Site Development Plan_V1.pdf Markup Summary

HIGHWAY 24 & MERIDIAN ROAD SITE DEVELOPMENT PLAN

SITE DEVELOPMENT PLAN
LANDSCAPE
HIGHWAY 24 & MERIDIAN ROAD
FALCON, CO

**LS04**

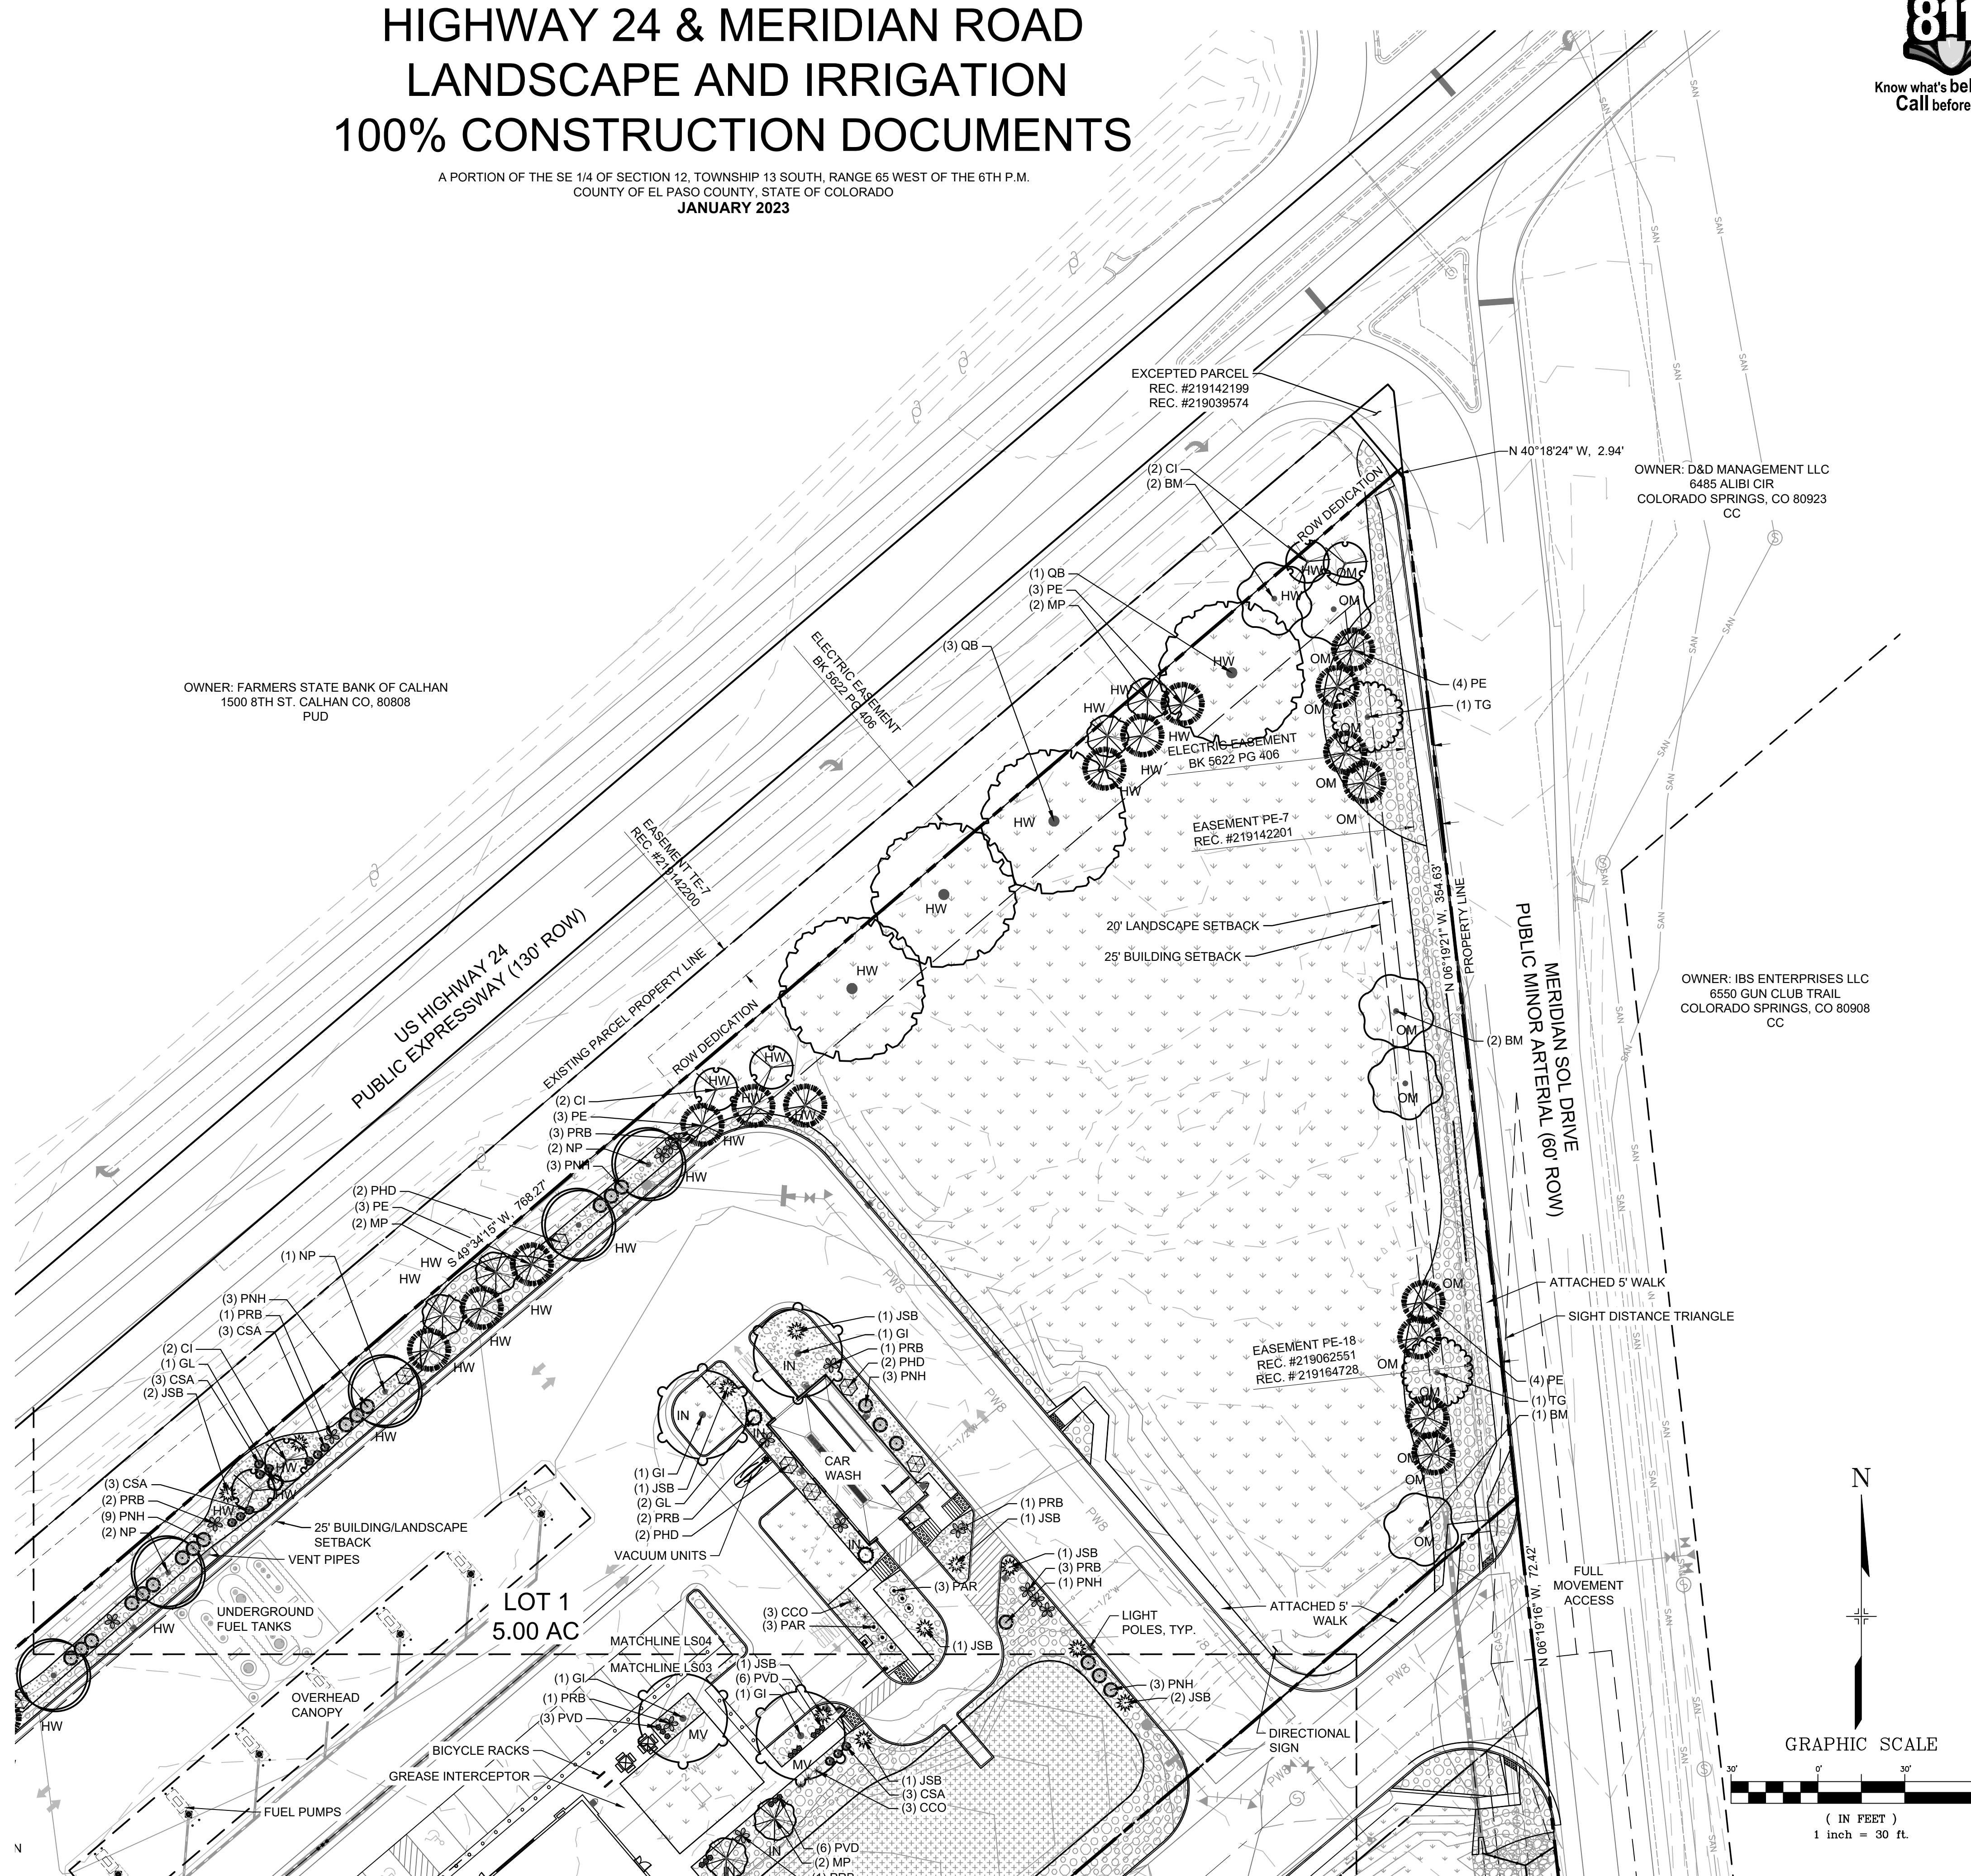
Spillway to be Type VL Riprap. Landscape Plan within SDP doc shows 2-4" cobbles here. Revise Landscape plan to remove cobbles from spillway area.
